24 July 2012

(Your Ref: MP10_0177 MOD 10)

**RE: COUNCIL SUBMISSION TO MP10_0177 MOD 10, AMENDED
APPLICATION FOR MODIFICATION OF MAJOR PROJECT APPROVAL UNDER
SECTION 75W**

CHILDCARE-POOL PLANS & ELEVS
SCALE 1:200

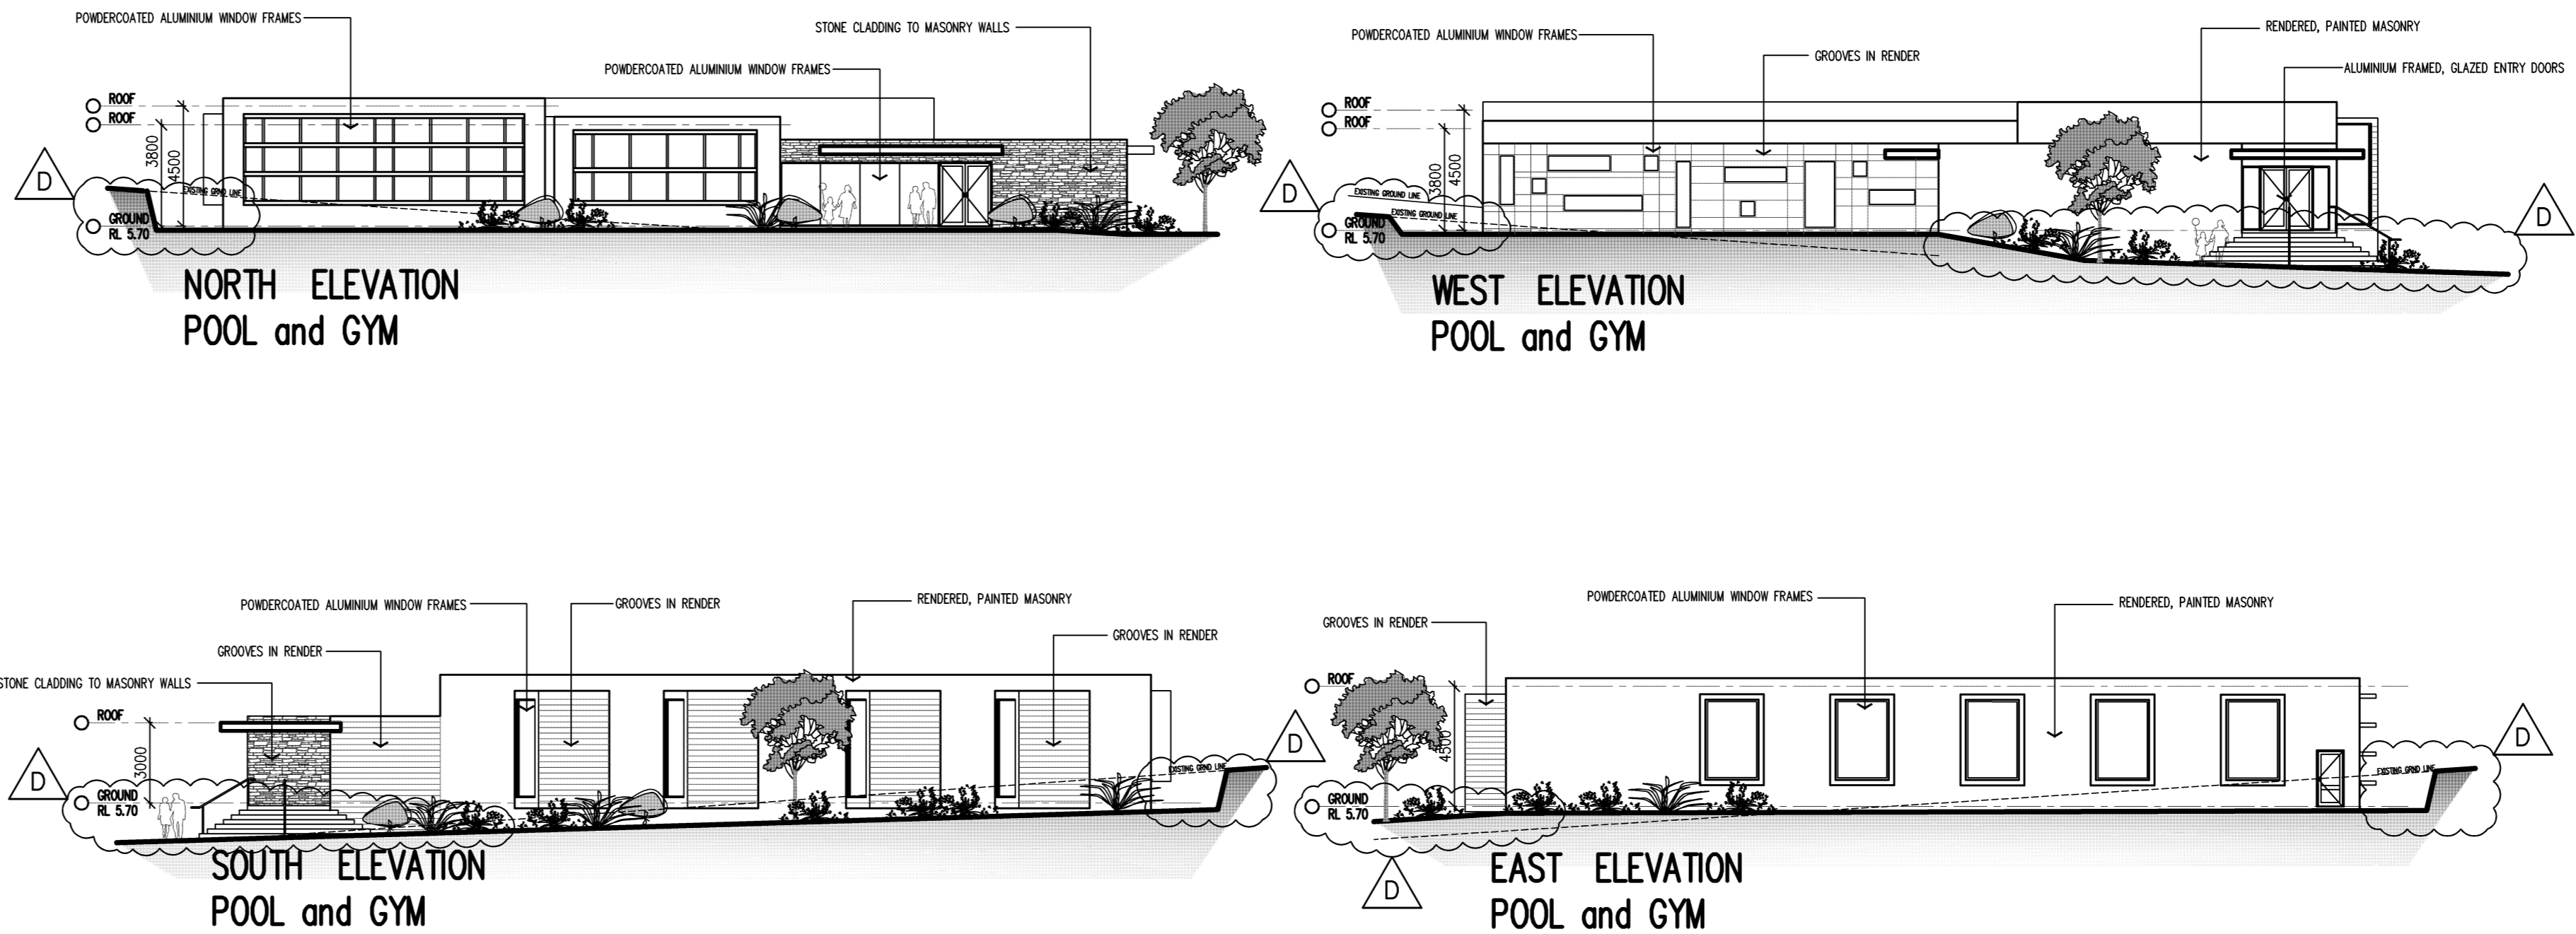
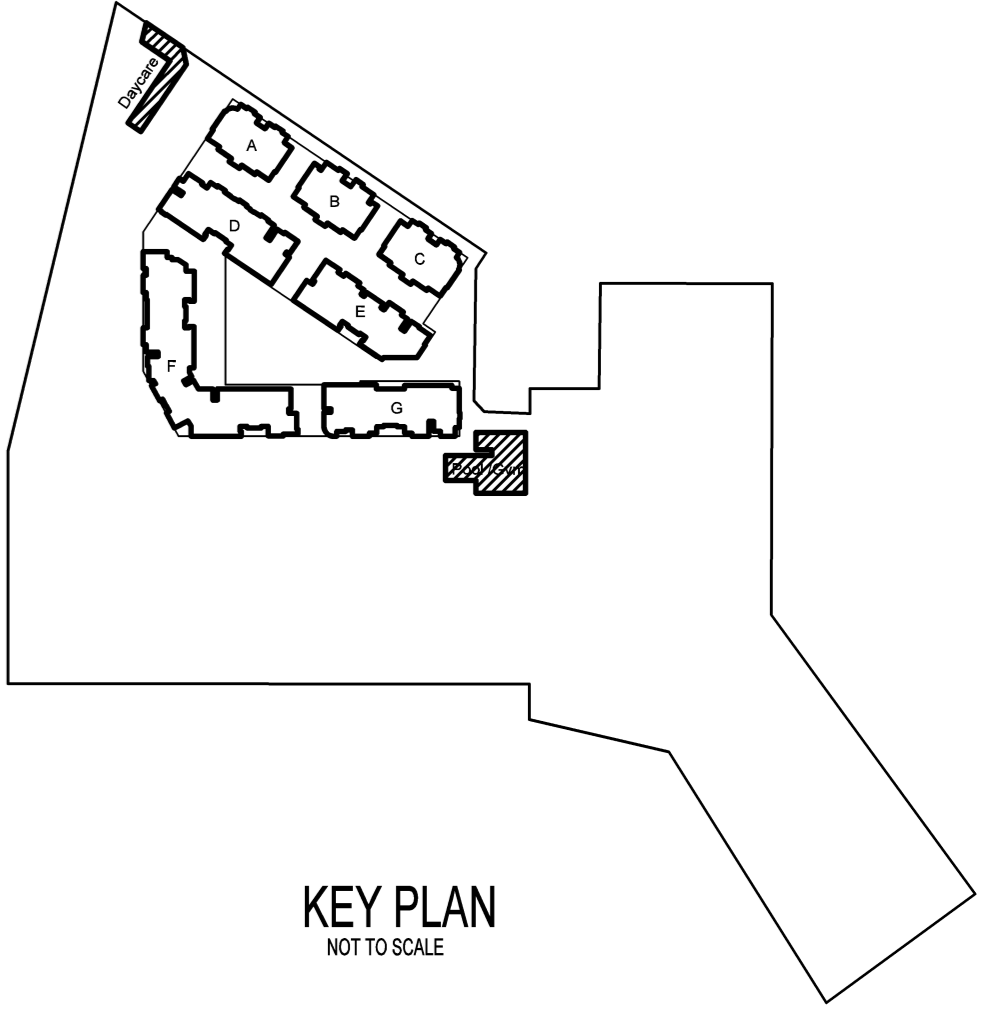
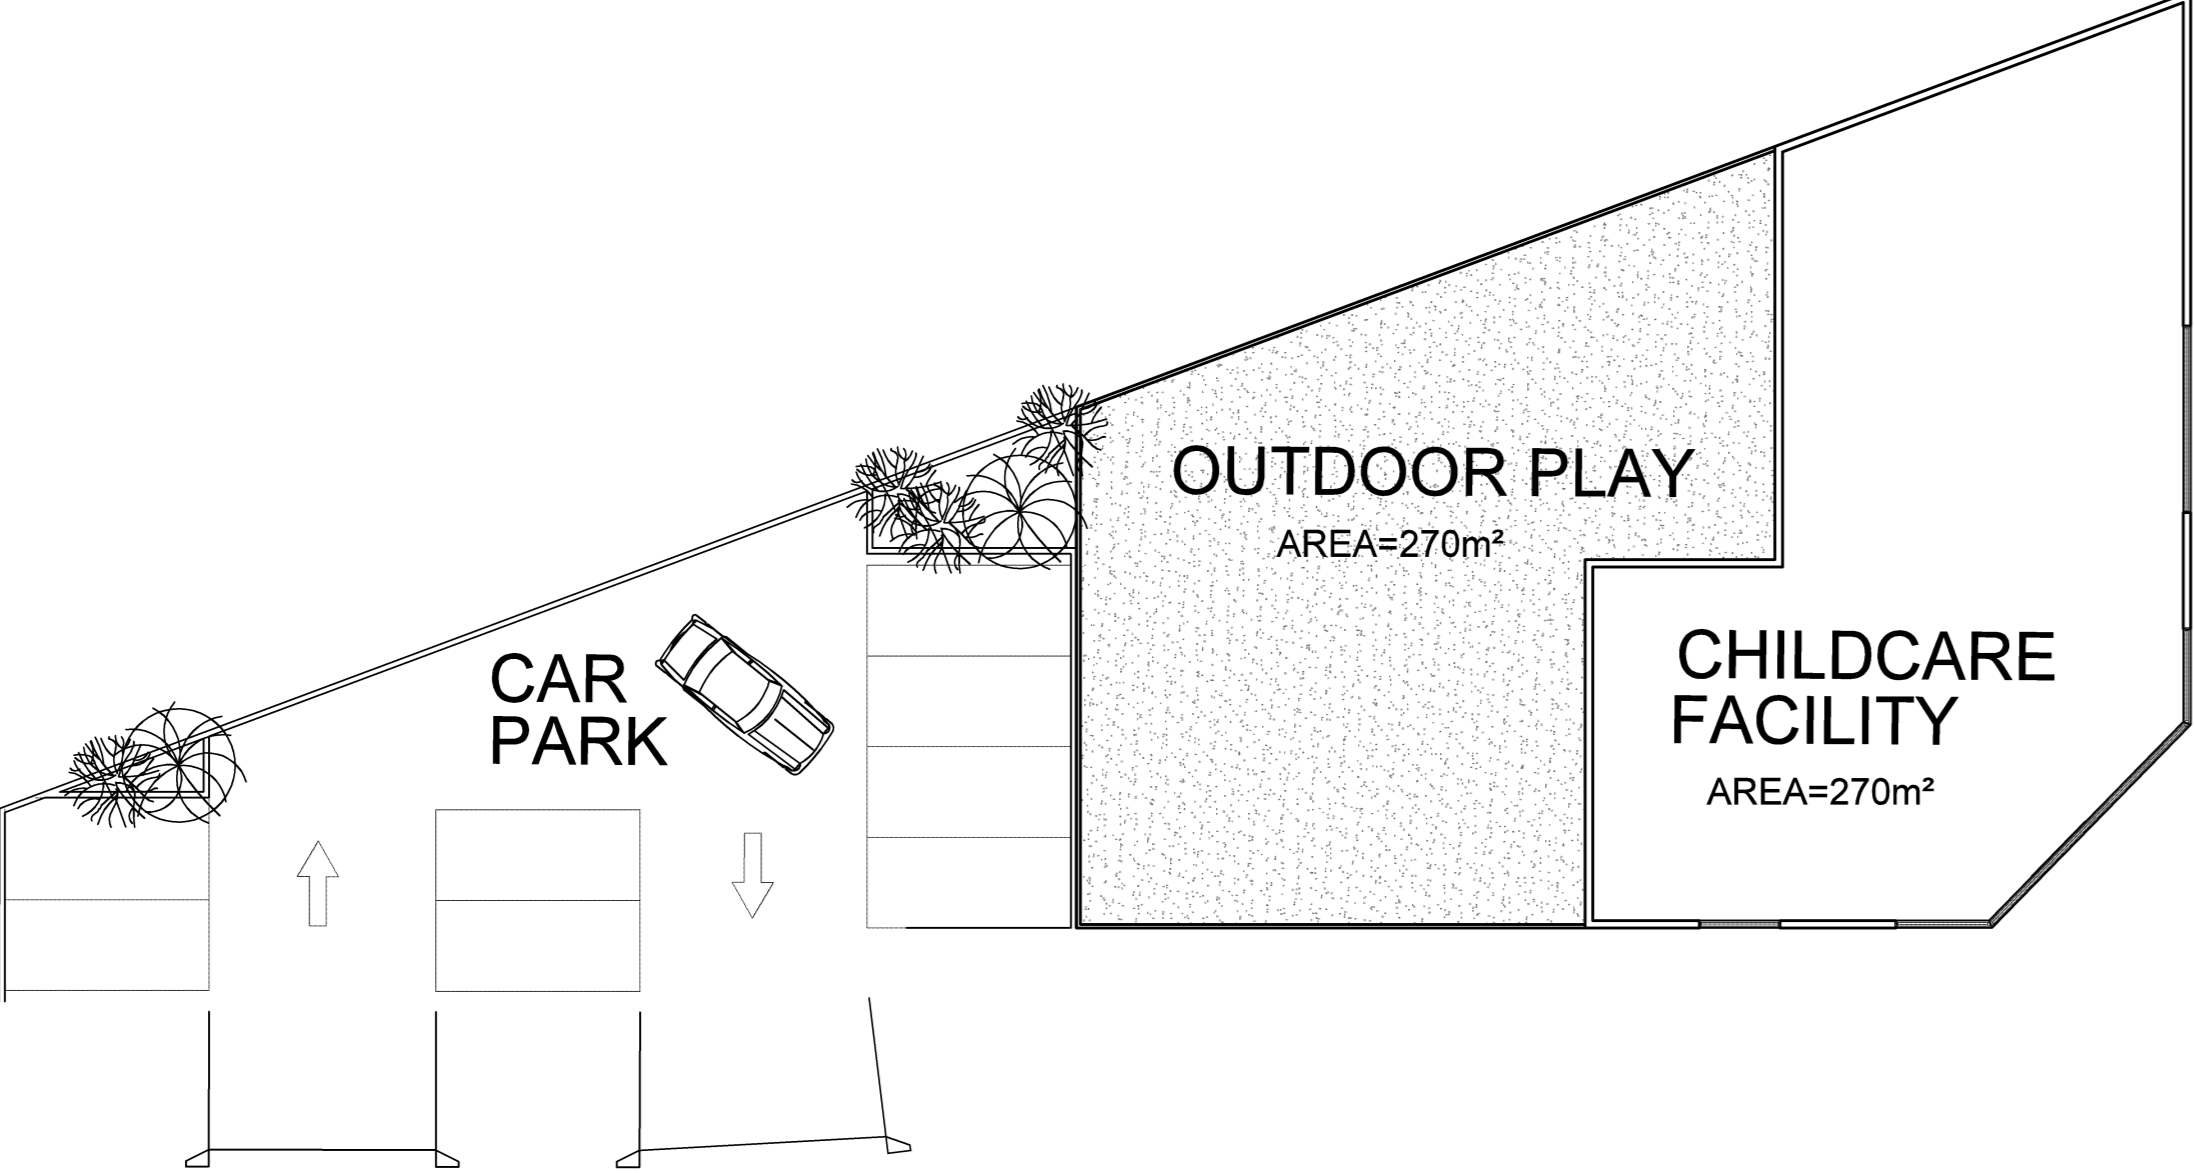
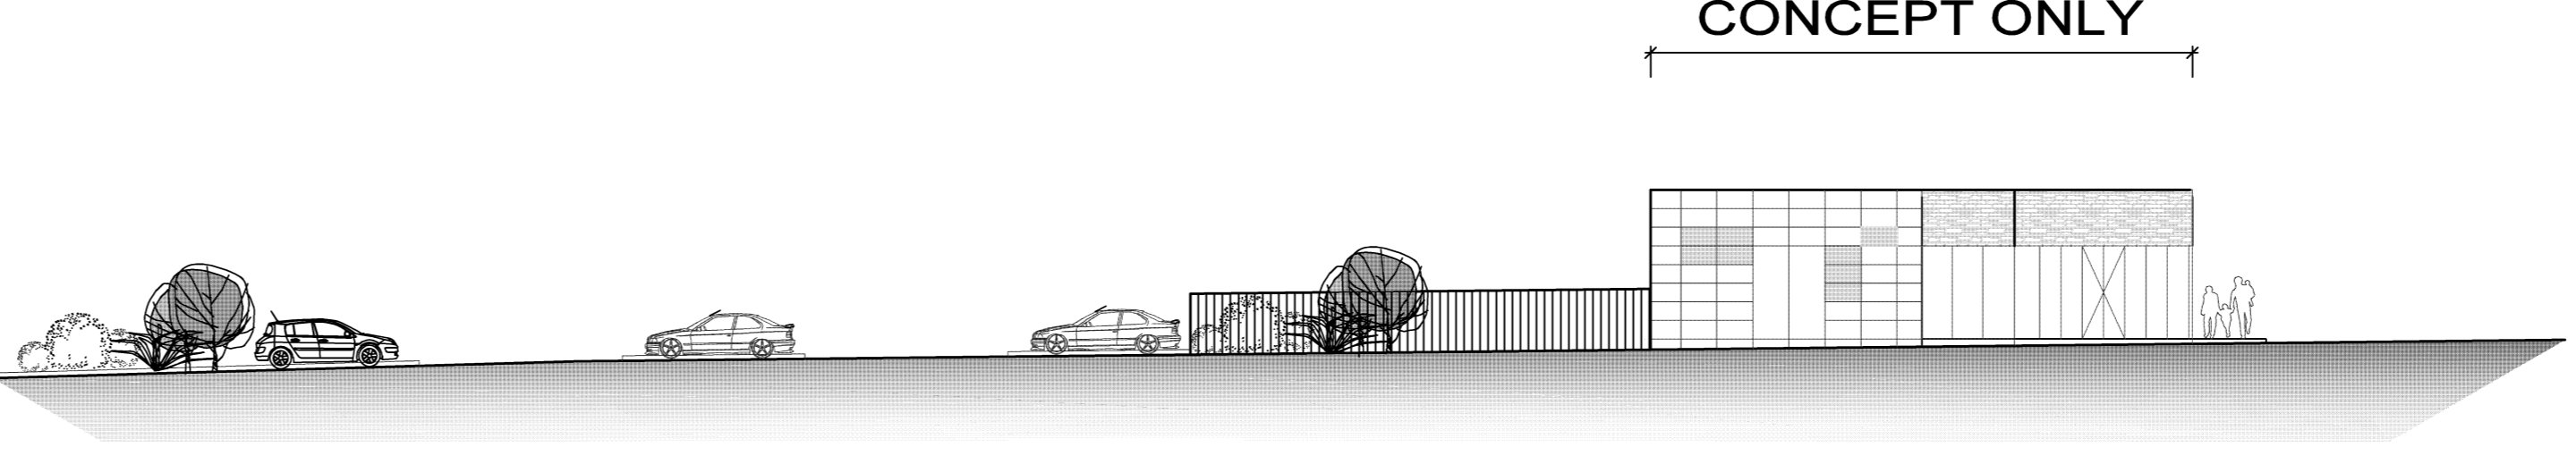
- Amend the finished ground level of the building from RL 5.00 to 5.70, and amend condition A1 to make reference to plan DA30 revision D.

Council does not, in principle, object to the modification application.
